Application Ref:	3/2024/1029			 Ribble Valley Borough Council <small>www.ribblevalley.gov.uk</small>
Date Inspected:	14/03/2025	Site Notice:	14/03/2025	
Officer:	MC			
DELEGATED ITEM FILE REPORT:				REFUSAL

Development Description:	Proposed construction of two agricultural workers dwellings with access and parking.
Site Address/Location:	Bolton Fold Farm, Alston Lane, Longridge, PR3 3BN

PROPOSED PLAN AND ELEVATIONS

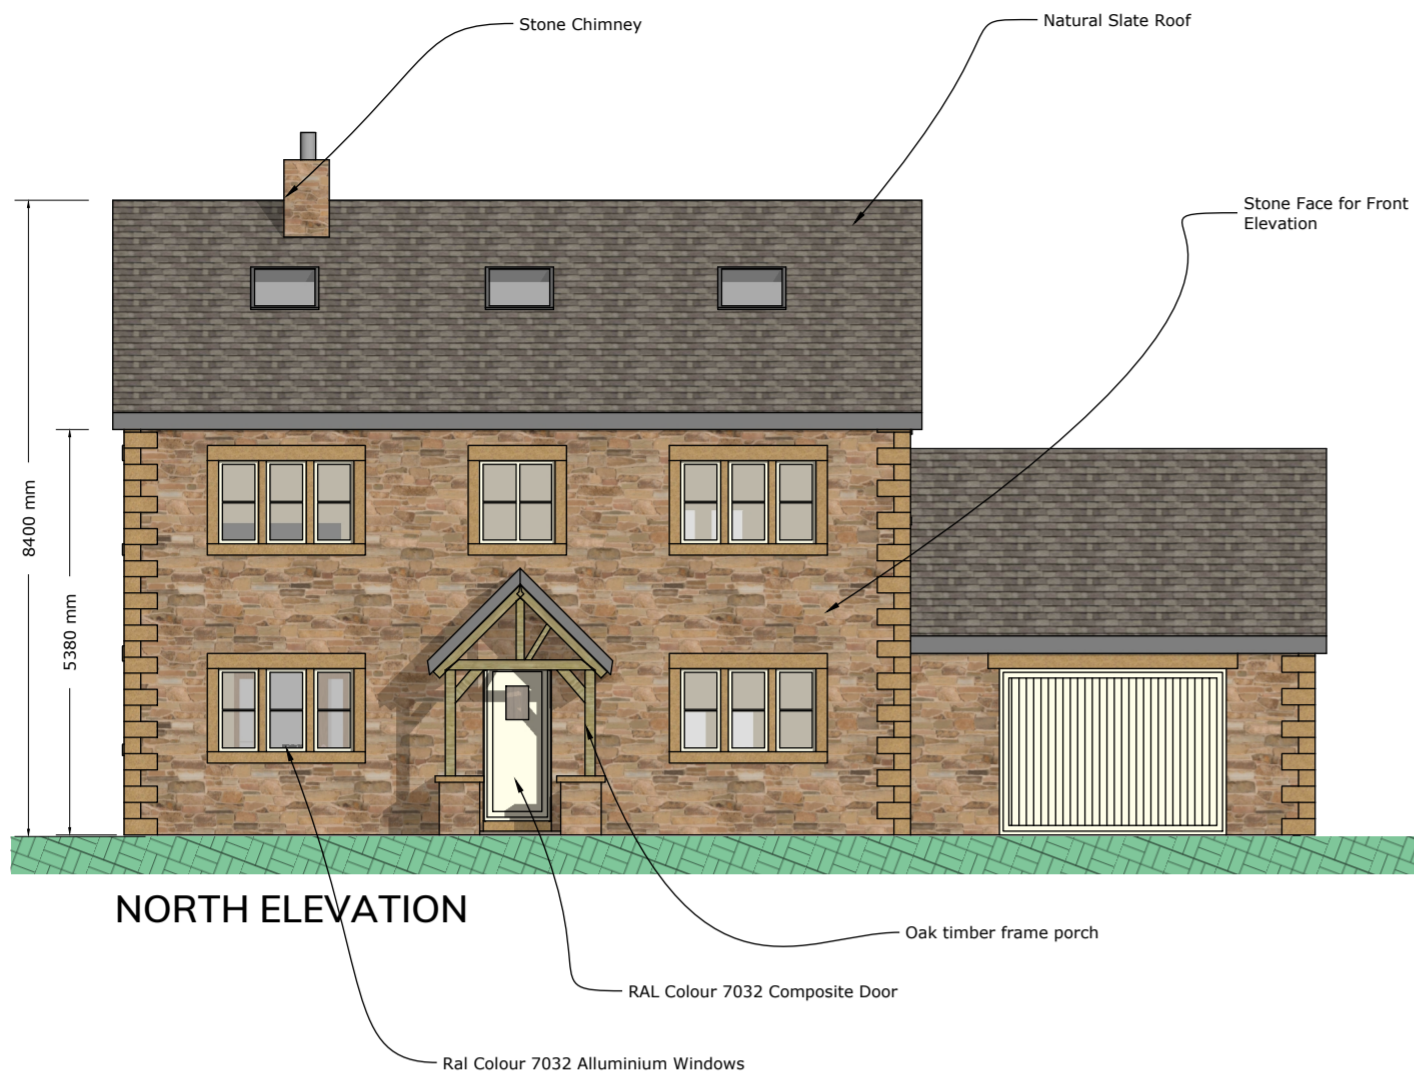
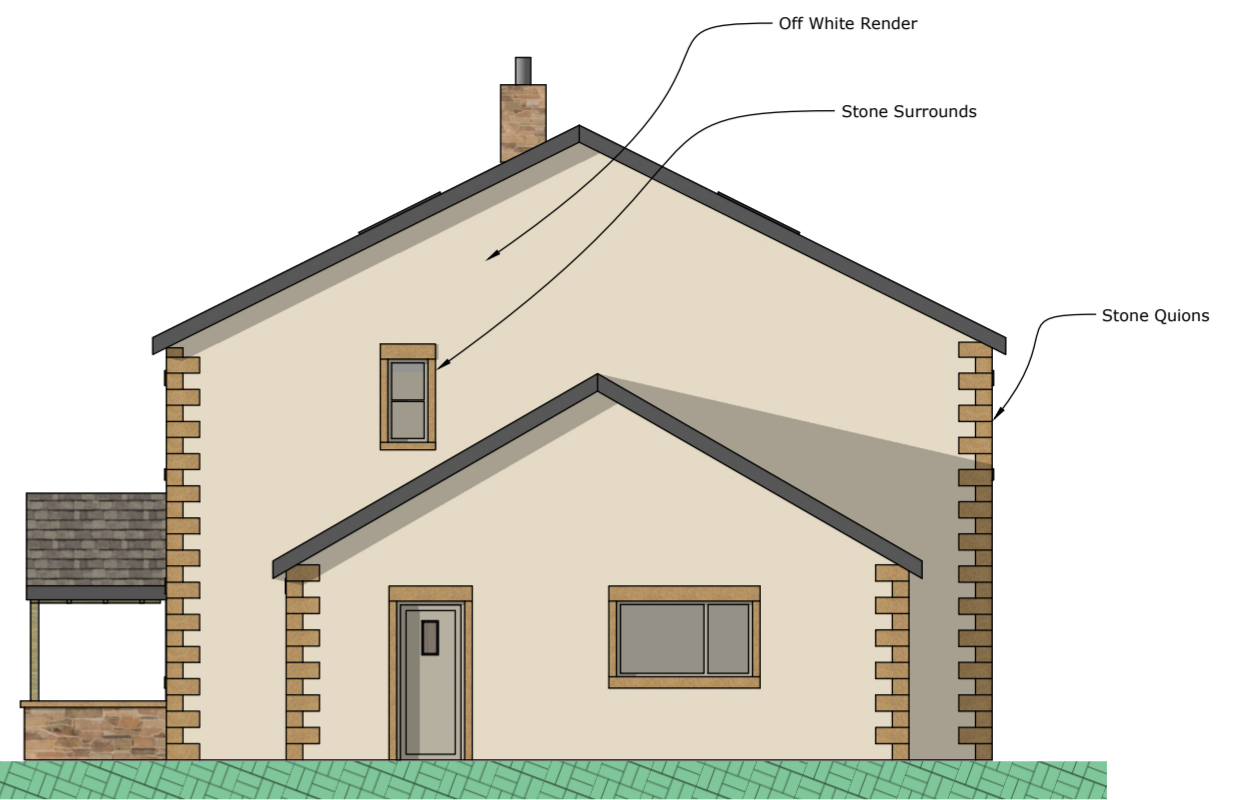
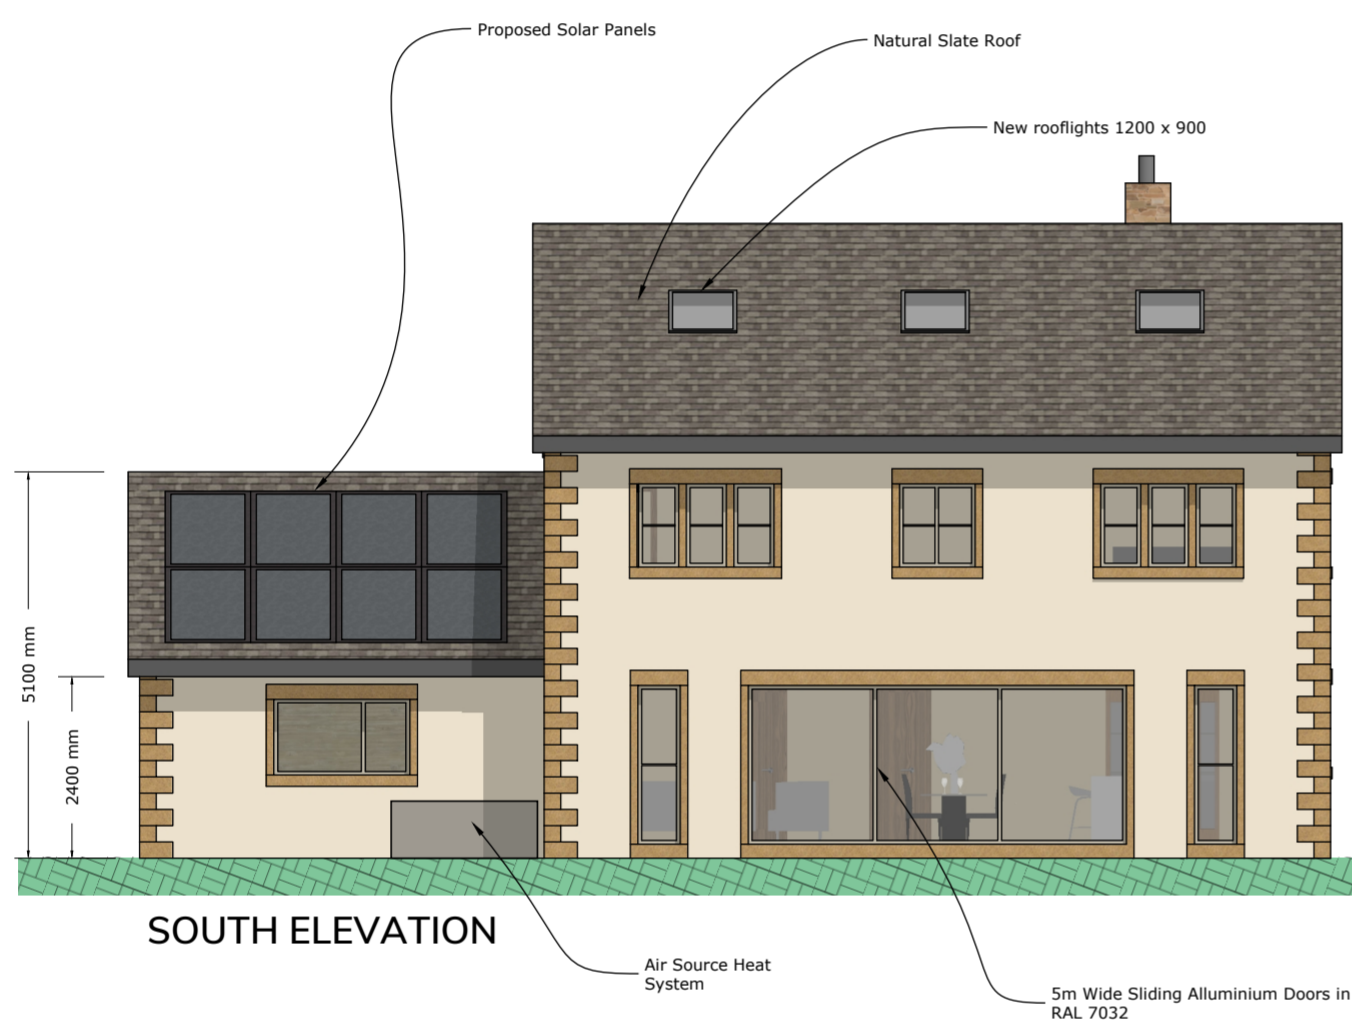
Notwithstanding this, proposed development would be located in a prominent position with the site running parallel to the boundary with Alston Lane. As such, the dwellings would be highly visible from the public realm, in an area currently void of built form. The dwellings are considered to be large in size and scale with a height of approximately 8.4 metres with a gable ended roof. The dwellings are considered to be substantial in floor area as well, with a floor area of over 270sqm and a depth of over 10 metres. The depth of the dwellings is considered to be excessive and would result in a large, gable ended wall facing Alston Lane. The dwellings have been positioned so that the single storey garage element is sited away from the site boundaries, however this would result in there being a gap of approximately 3.4 metres from the western boundary to the two-storey flank wall. The size and scale of the dwelling in this location, being so close to the site boundary is not considered to be acceptable and would result in harmful bulk and massing, located in a prominent position within the street scene which would fail to respond positively to the local character, where the dwellings at the entrance to Alston Lane are single storey at the closest point to the roadside which helps to reduce their prominence. In addition, the eastern dwelling would be located in close proximity to an existing building within the farmstead. Whilst this is single storey and as such would help to mitigate any visual harm by additional bulk, it does raise concern that the footprint of the building is too large in relation to the plot size/shape.

In addition, the dwellings include the addition of 6 no. rooflights each which would give the appearance that they are 2.5 storeys in height which is not fully justified, given they are for agricultural workers. It is also considered that the driveway to the front of the site would result in a large expanse of hardstanding, with little way of soft landscaping features between the two properties. Had the application been recommended for refusal, an alternative soft landscaping scheme could be secured.

01:	The proposed development would fail to accord with the local character of the surrounding area, resulting in harm to the character and appearance of the street scene by way of the size, siting and design of the proposed dwellings which would be unduly prominent within the street scene, contrary to Policy DMG1 and DMG2 of the Ribble Valley Core Strategy and Policy LNDP3 of the adopted Longridge Neighbourhood Development Plan.
